Submissions report

Crows Nest TOD State Significant Development (SSD-83076206)

402-420 Pacific Highway, Crows Nest

Prepared on behalf of X Quantum Pty Ltd

Figure 11 Proposed site access arrangements

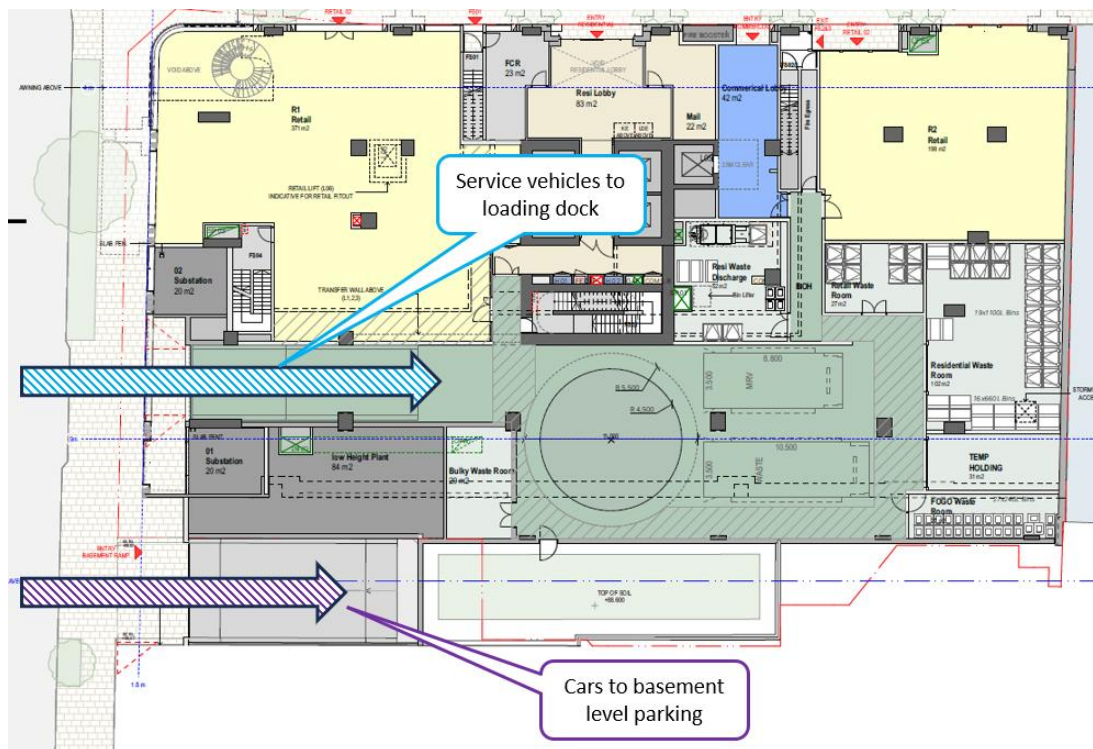
2. Driveway access		
2.1	Prioritise pedestrian amenity and movement along Oxley Street by consolidating access points and reducing both the number and width of driveway crossovers.	The driveway access has been reconfigured to accommodate access to all car parking within basement levels via the existing driveway from Oxley Street with a second dedicated loading dock access provided from Oxley Street. Amenity for pedestrians along Oxley Street has been enhance as follows: • Reduction in overall width of the crossovers in comparison to the originally submitted proposal, with the widths minimised to reflect the swept paths of the design vehicles • For the loading dock access reduction to a single lane driveway which will reduce the extent of public domain impacted • The provision of a break between the driveways of approximately 5m in width providing a pedestrian refuge between the two driveways.

No.	Comment	Response
		In contrast, the original proposal included a continuous crossover totalling over 15m in width.
2.2	Continue engagement with adjoining landowners to resolve basement and boundary constraints, with the aim of rationalising access arrangements and facilitating a more efficient and cohesive development footprint.	Since the exhibition of the EIS, the applicant has been in ongoing discussions with Wee Hur, the developer of the adjoining site at 35-51 Nicholson Street, to coordinate the design and delivery of both projects. The applicant has been working with Wee Hur to come to an agreement on shared building separation, a future realignment of the irregular shared boundary, and extinguishment of easements to facilitate an integrated and orderly redevelopment outcome across both sites. This is discussed in further detail in the Amendment Report.

Figure 16 End of trip facility

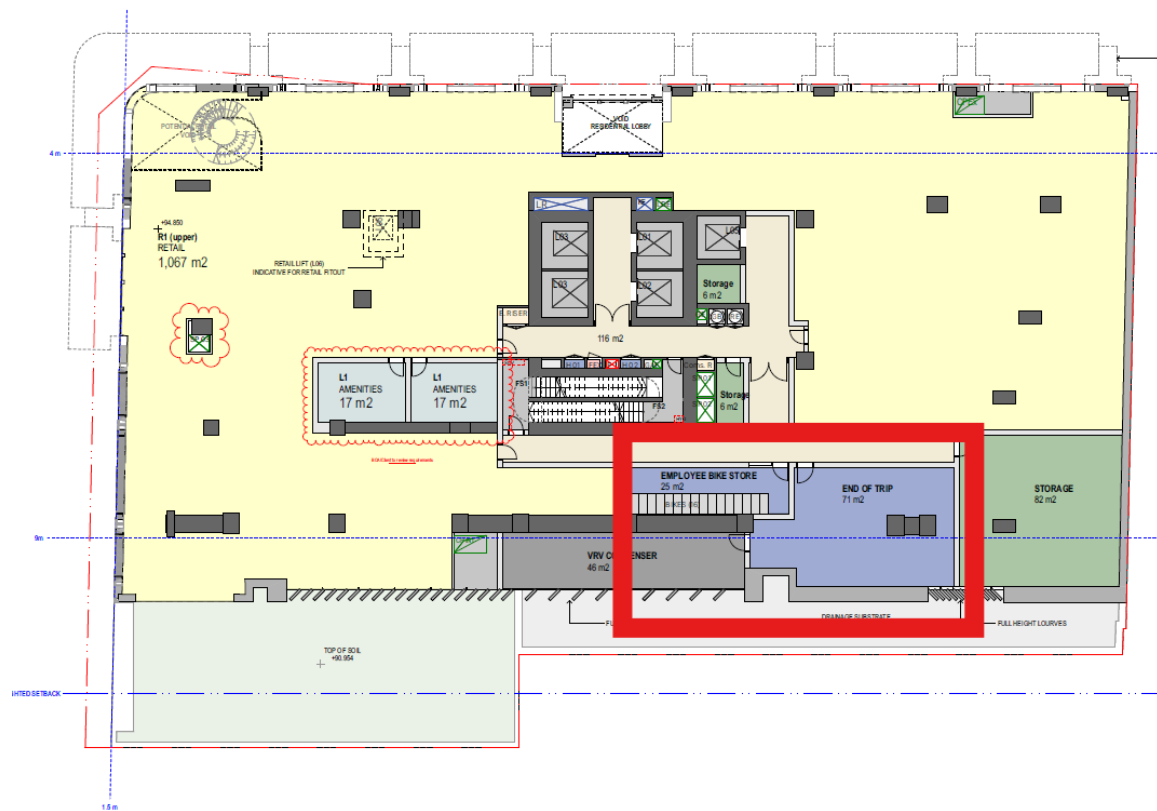
5. Bicycle parking and end of trip facilities		
5.1	Incorporate end-of-trip facilities for commercial premises workers, as recommended in the Transport Impact Assessment.	An end of trip facility has been included in the podium as outlined in the Amendment Report.
